From: Janice Chapman
Sent: 19 August 2013 16:48
To: 'Ann Truman'
Subject: RE: Application Number AW/134/13/T

From: 
Sent: Janice Chapman
16 August 2013 15:44
To: 
Subject: AW/134/13/T - Fell 3 no. Leylandi trees and crown reduction of 1 no. Holly tree by 2m and reduce branches by 2m-3m.

4 = HOLLY TREE (IN EXCESS OF 30' TALL + SPREAD)
AROUND 30'

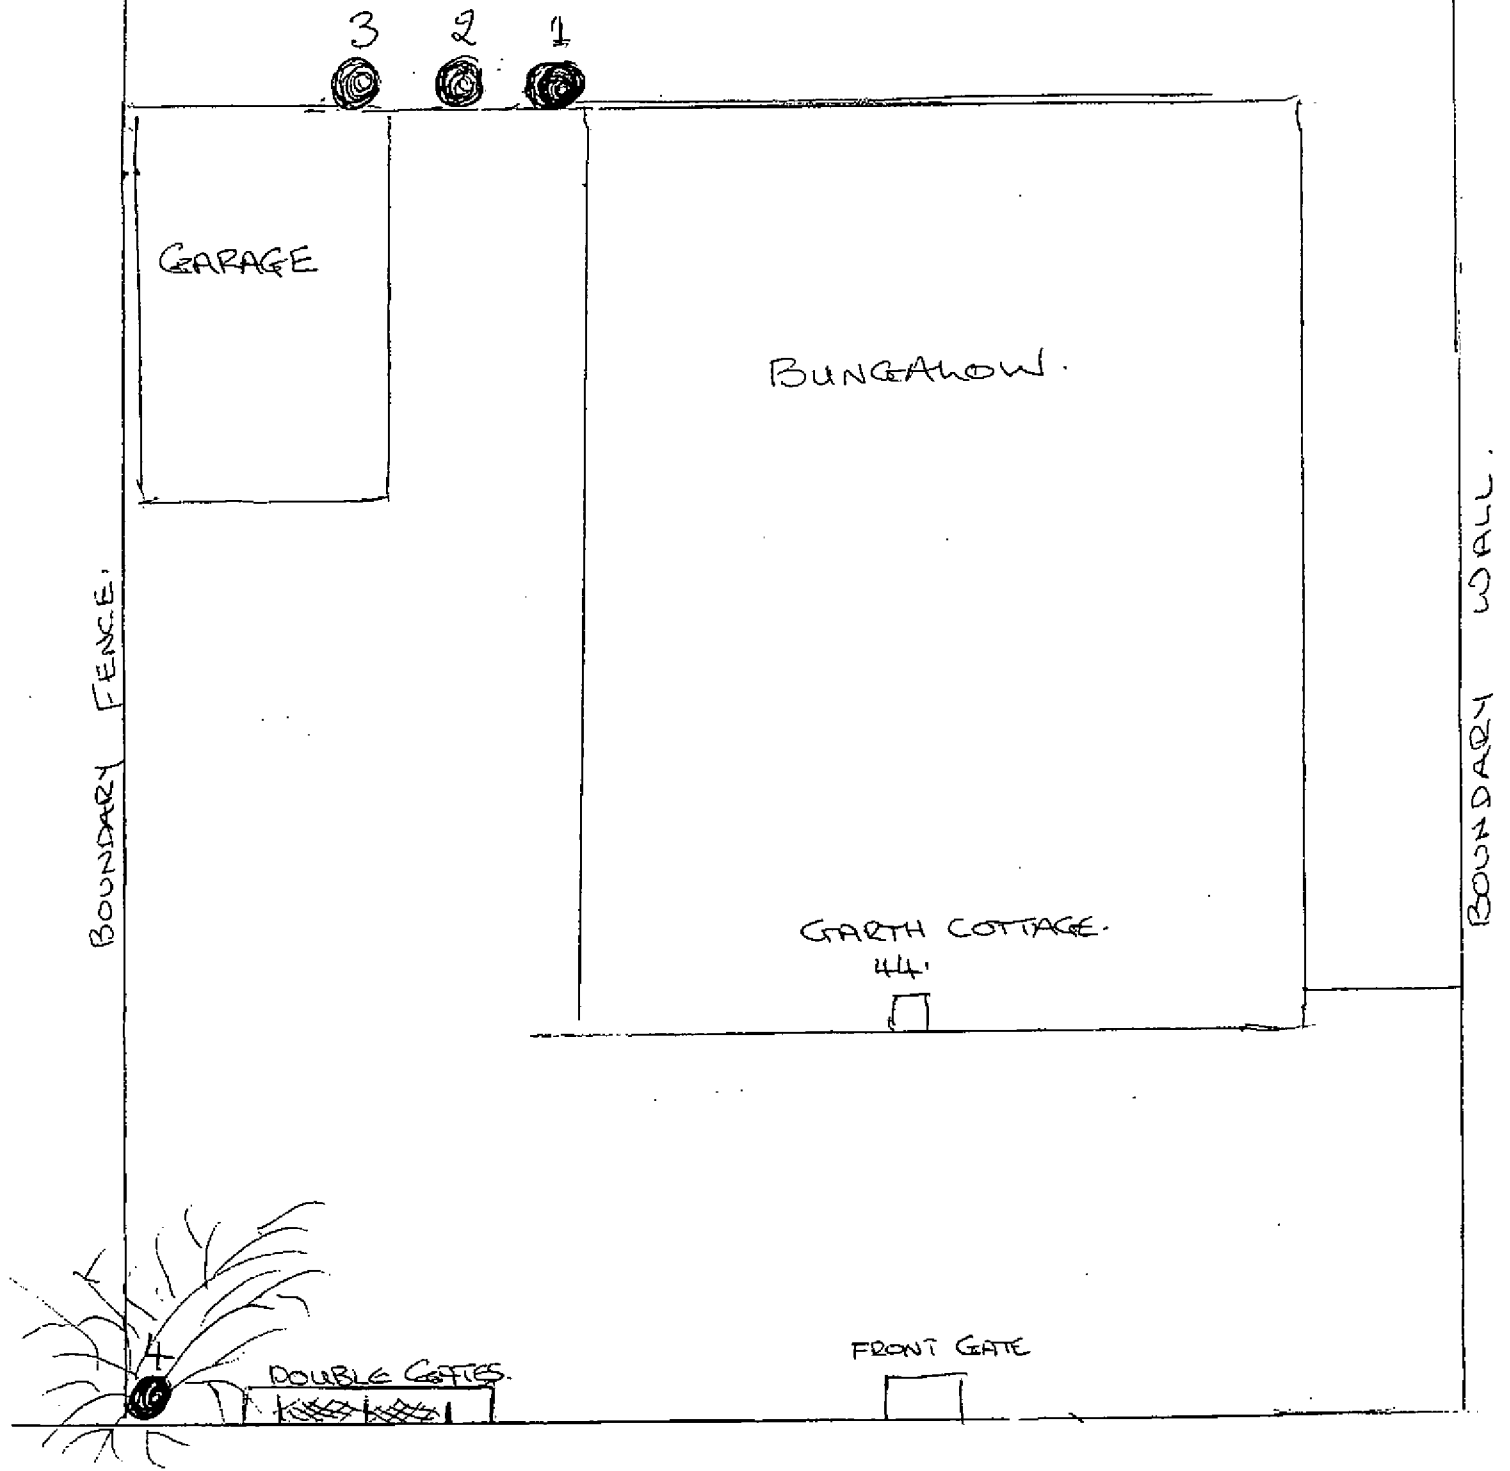
I have just received the comments from the Council's Arboriculturist in respect of the above surgery to the trees. Whilst he has raised no objection to the removal of the 3 Leylandi trees he has raised an objection to the reduction of the crown to the Holly tree. As the tree is of significant public visual amenity the proposed surgery would diminish the visual amenity of the tree. There may be scope to have the overhang lower crown lifted to provide clear access for pedestrians if this is causing a problem.

In view of his comments the application cannot be approved. If the Holly tree were to be removed from the application or amended to a crown lift by 2.5m from ground level then the description could be amended and approved.

In view of the contents of your e mail regarding the above application, would you please remove the Holly Tree from the application. Although the Holly Tree in our opinion looks uncared for and a mess, the Leylandii trees are our immediate concern. Can we please instruct a Tree Surgeon to remove these as soon as possible?
